City of Portland, Maine - Building or Use Permit Application

Location of Construction: 79 COTTAGE PARK RD	Owner Name: HYMAN WILLIAM A	Owner Address: 79 COTTAGE PARK RD	Phone:
Business Name:	Contractor Name: Steve Nevers/NEVCO	Contractor Address: 98 Haley Road Hollis	Phone: 2079290996
Lessee/Buyer's Name	Phone:	Permit Type: Additions - Dwellings	Zone: R-3

Past Use: Single Family Home	Proposed Use: Single Family Home/Construct exterior deck and 3 season porch	Permit Fee:	Cost of Work: \$0.00	CEO District: 5
---------------------------------	--	-------------	-------------------------	--------------------

STAIR DETAIL

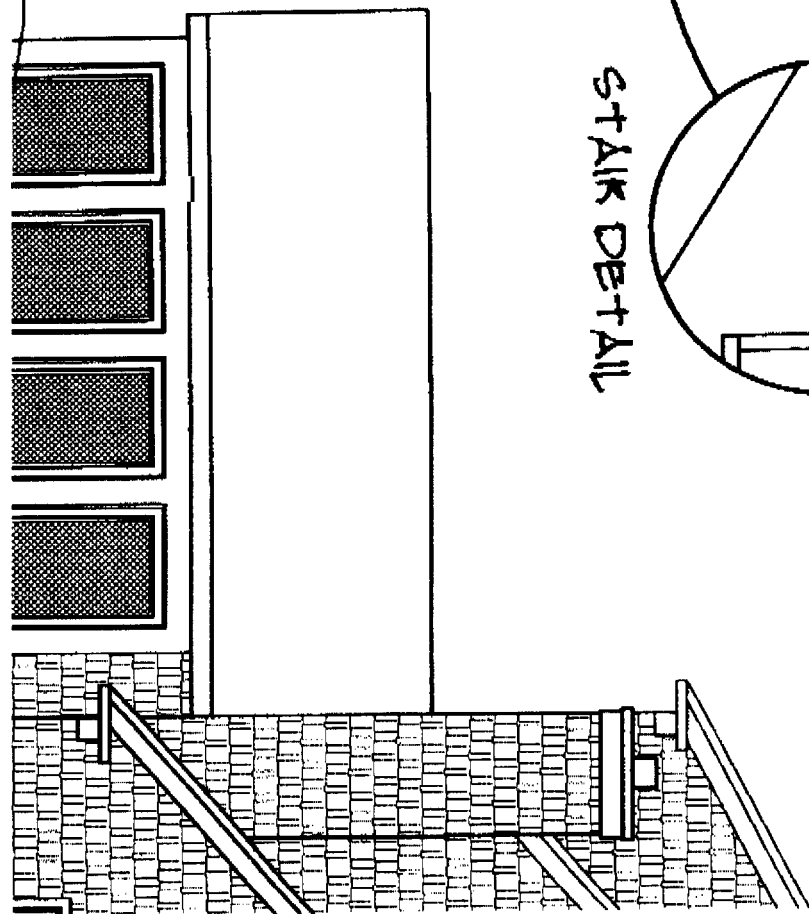
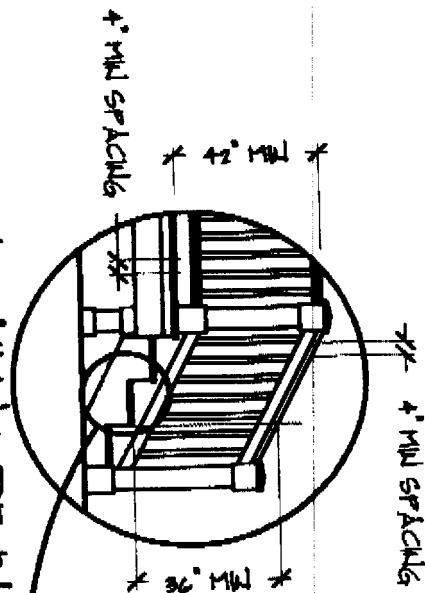
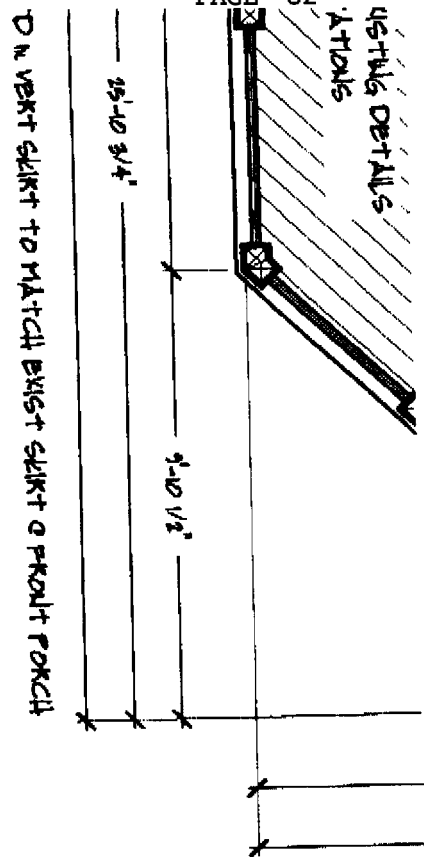
Comments:
 9/25/2006-tm: spoke to contractor and requested more info on stairs and rail system. He will have the info faxed to me asap.

~~THE~~ NOTE: "2X10 LEDGER" IS
LABELED ON THE FRAMING, PLAN
WHICH IS NOT ENCLOSED.
